SICEEP PPP – Response to Department of Planning and Infrastructure Submission

SCALE @ A3 1:2500	DRAWN JC	CO-ORD DG	REVIEWED DG	APPROVED AB
PROJECT NUMBER AX3688	DRAWING NUMBER SK_PP_LA_2056		REV A

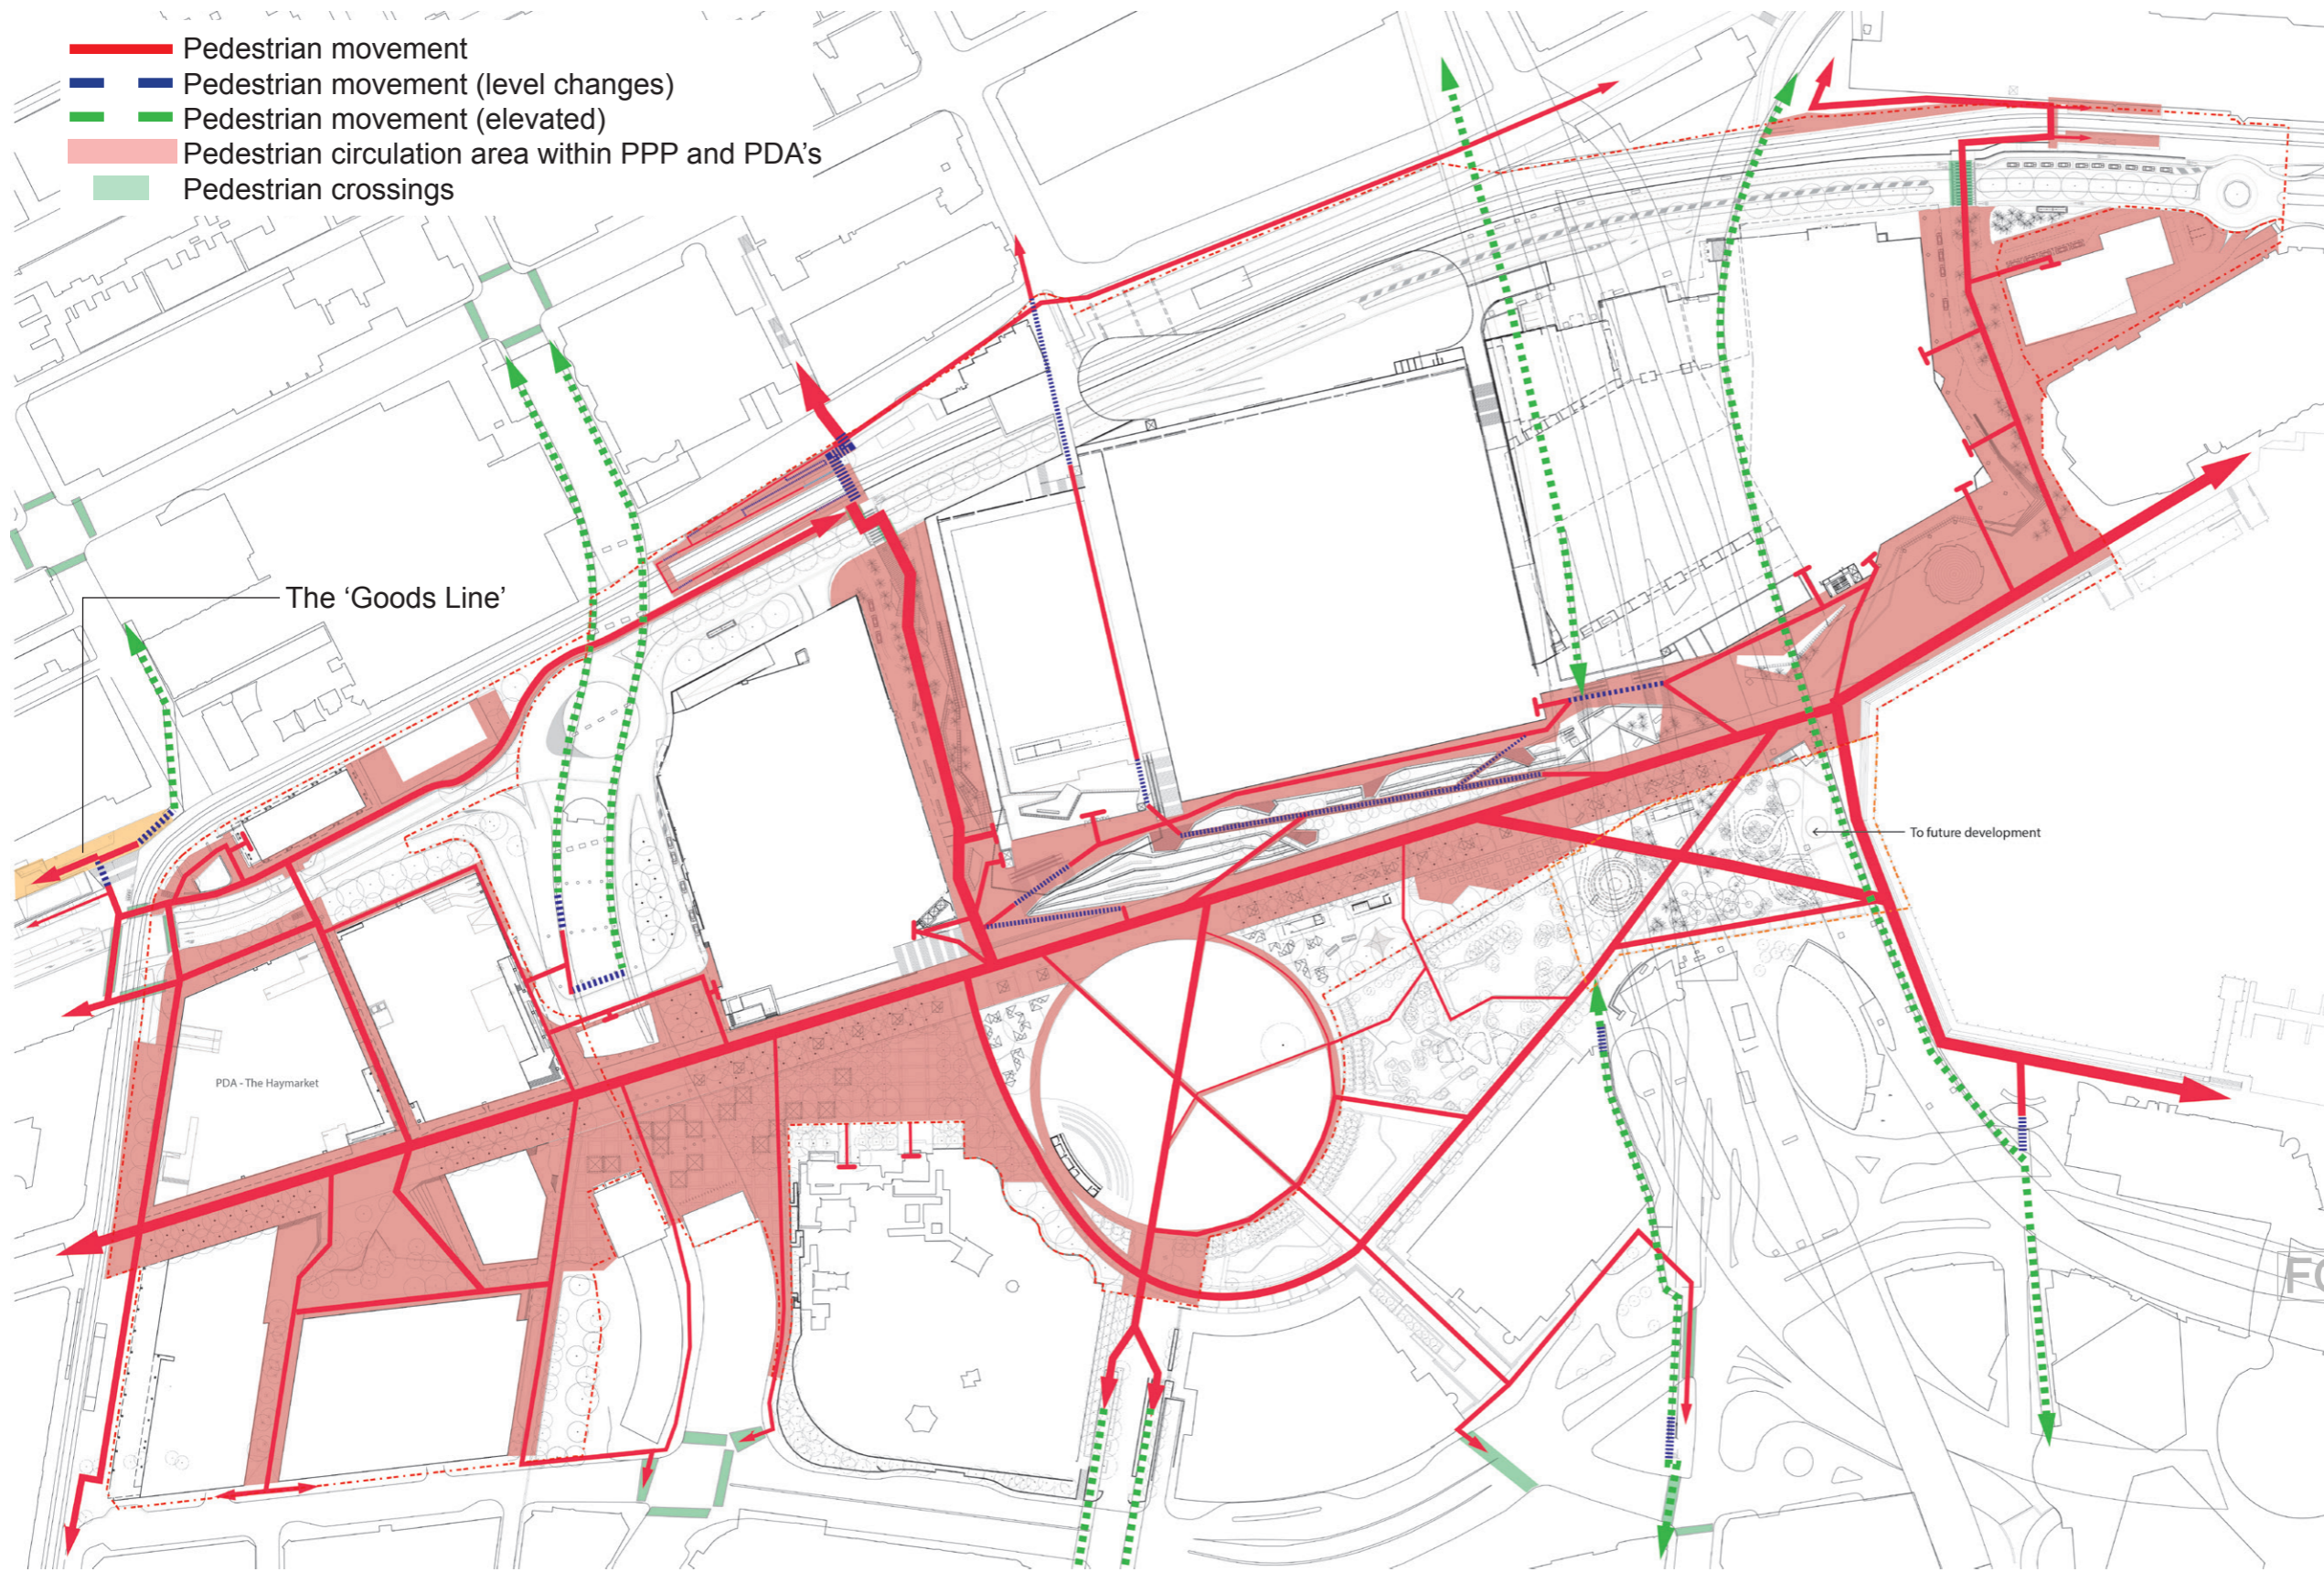
Item Number	Issue	Response
20. Pedestrian Network	Demonstrate how the Quarry Street pedestrian link across Darling Drive will provide a desired pathway for pedestrians given the level changes and restricted access across the event deck during event mode.	<p>The Pedestrian Networks diagram (SK_PP_LA_2056) and Level Transitions diagrams (SK_PP_LA_2057) prepared by HASSELL at Appendix K show the various pedestrian connections across the site and to surrounding areas, demonstrating an appropriate level of accessibility and connectivity with surrounding pedestrian networks.</p> <p>Diagram SK_PP_LA_2023 outlines the pedestrian route across the Quarry Street bridge and the Event Deck. Access will be maintained along the north side on the Event Deck and into the public realm via stairs, escalators and lifts. During certain private events, the Event Deck will be closed to pedestrians.</p>

TUMBALONG GREEN CHANGES

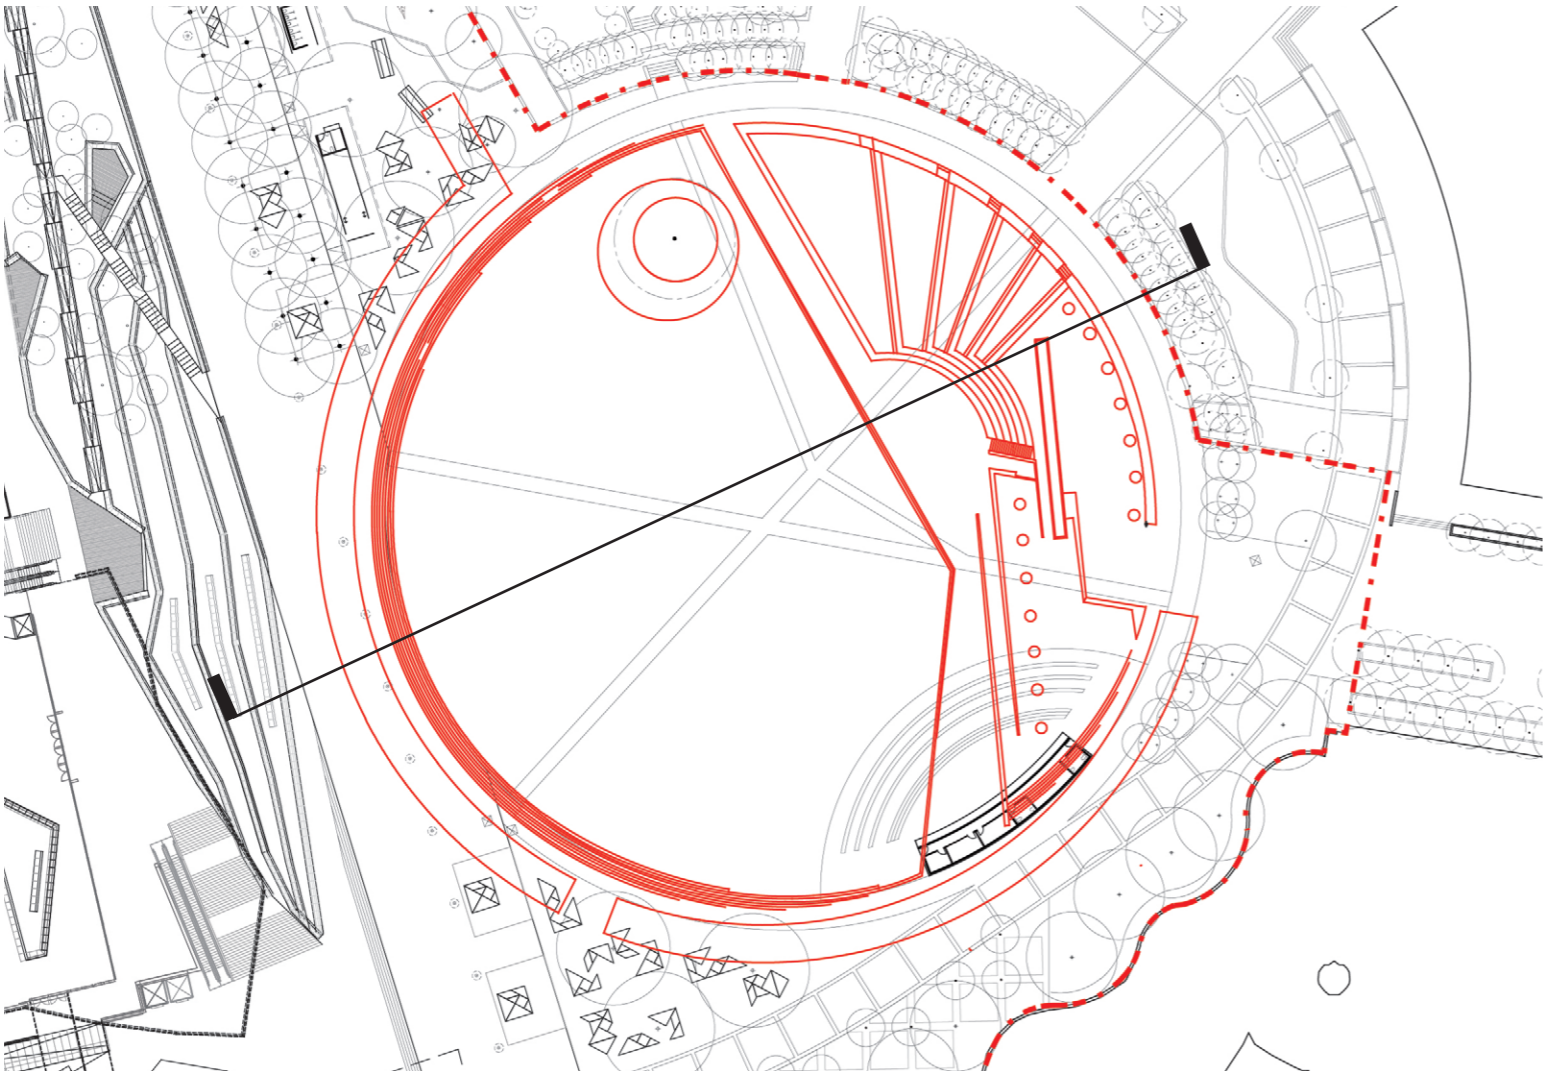
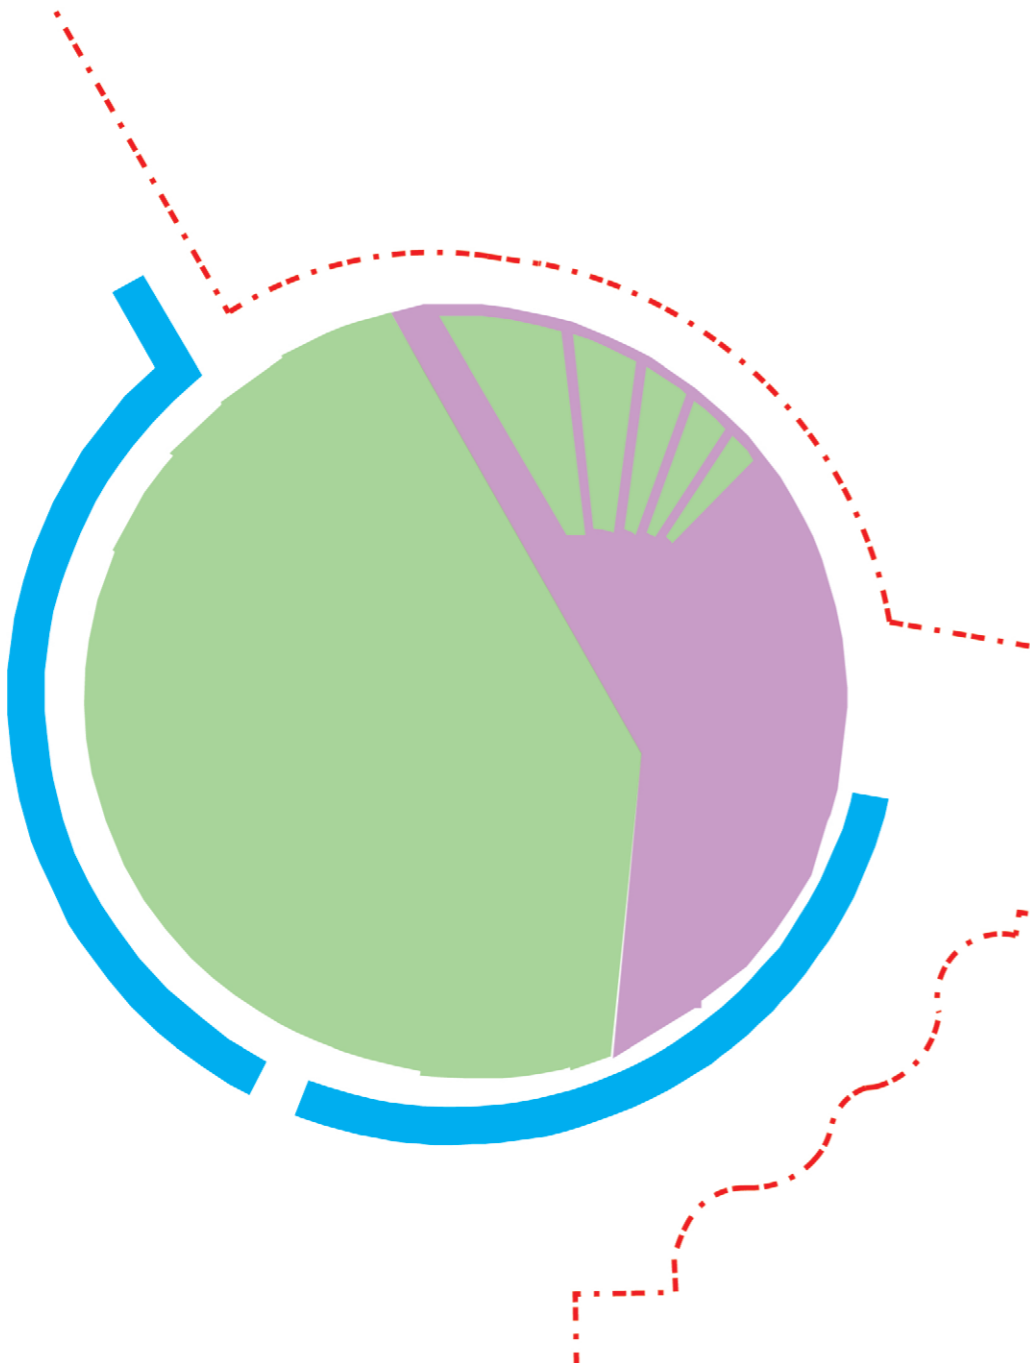
22. Pedestrian Network	Demonstrate that the size and scale of pedestrian paths across Tumbalong Green will be adequate to cater for projected volumes of people to and from Town Hall Station during event mode.	The footpath alignment and pathway geometry in and around Tumbalong Green has been amended to address the concerns raised by the Department (refer to diagram SK_PP_LA_2061 at Appendix K). Whilst DHL has considered widening the paths to cater for people movements in large events, this would change the character of the Green, and would mean that it was defined by the paths instead of green space which is its primary role. Further, it is considered that primary pedestrian movement from Town Hall into SICEEP will also include the significant circulation zones around Darling Quarter and the Chinese Gardens, and not just Tumbalong Green in isolation. As a result, it is not considered necessary to widen the paths for events.

23. Pedestrian Network	Incorporate a wider footpath on the southern side of Tumbalong Green which avoids the backstage area.	DHL concurs with Council's comments and will address this further during design development. HASSELL has prepared a diagram for the Tumbalong Green Pedestrian Network (refer to diagram SK_PP_LA_2061 at Appendix K , and Section 2.5 of the Response to Submissions report) which gives an indication of the revised geometry. This is a matter appropriately dealt with via condition of consent requiring final detailed design prior to issue of a construction certificate for public domain works.
